Our Ref: BN/48/18/PL
Your Ref:

Town & Country Planning Act 1990 (as amended)
Town and Country Planning (Development Management Procedure) (England) Order 2015
Application for Planning Permission

Development Removal of existing building and erection of two new dwellings
Location Land north of Sunnyside Cottages Yapton Road Barnham

Block Plan

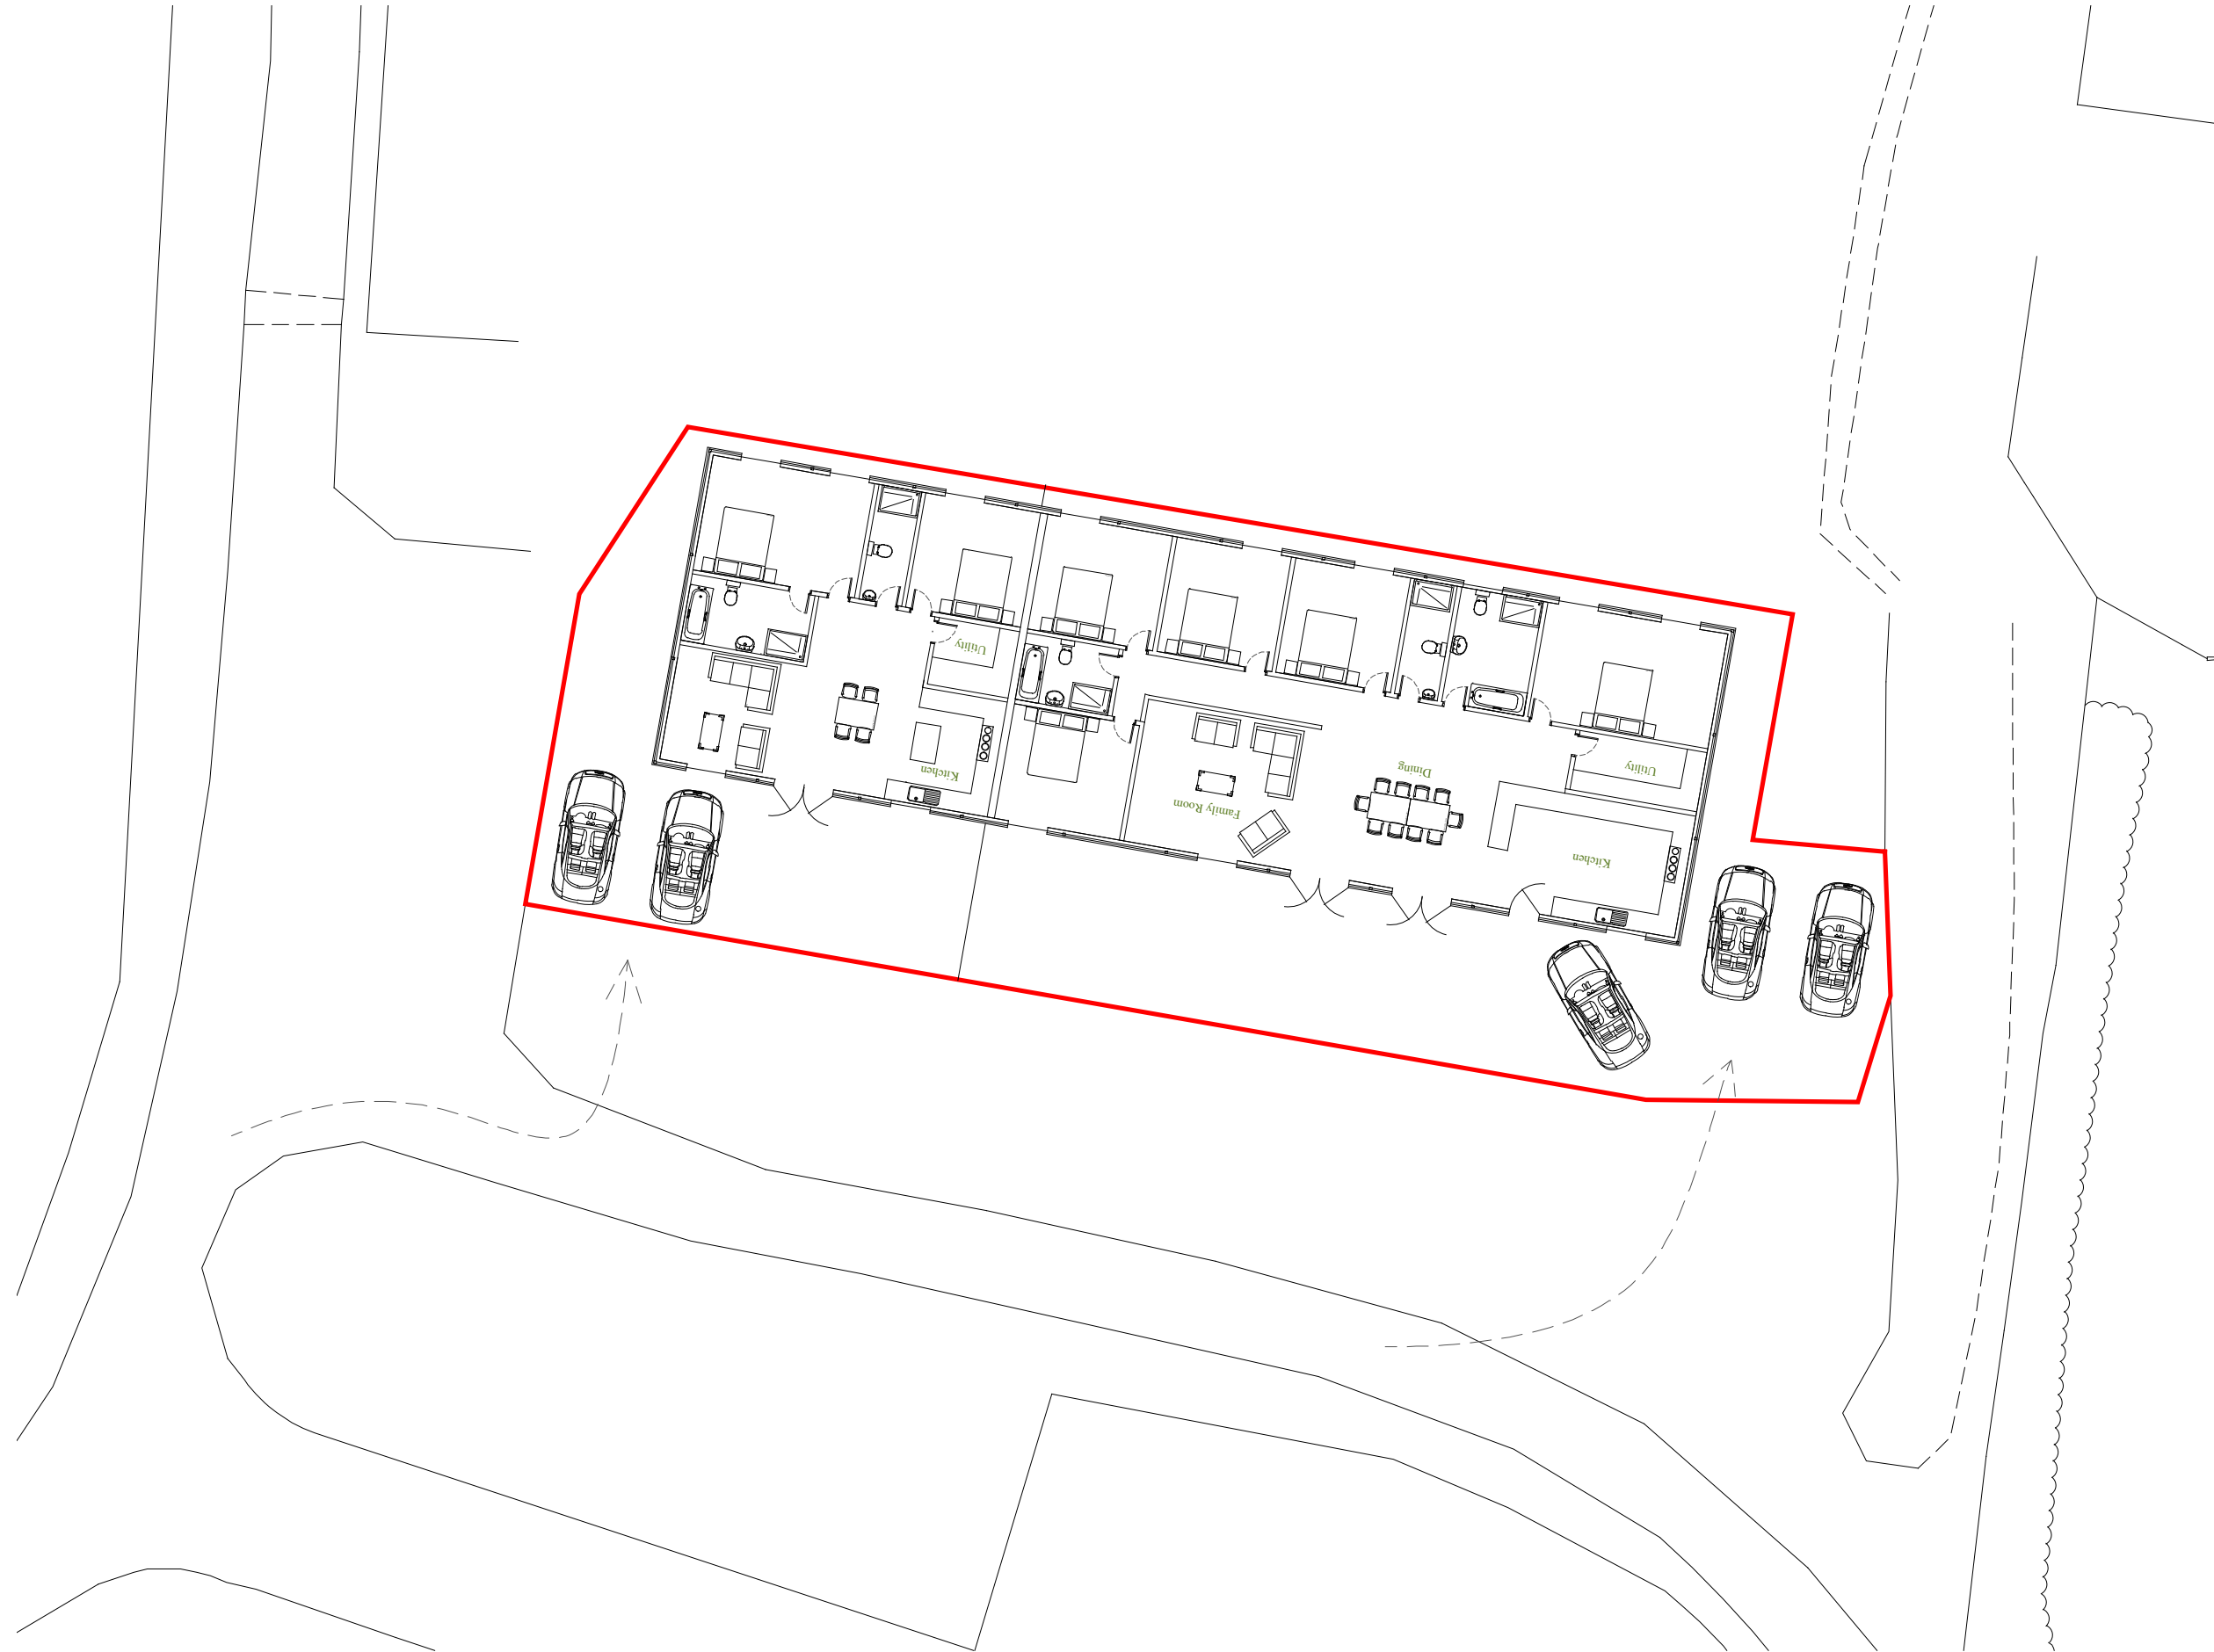
Please annotate the dimensions from the proposed dwellings to the site boundaries.
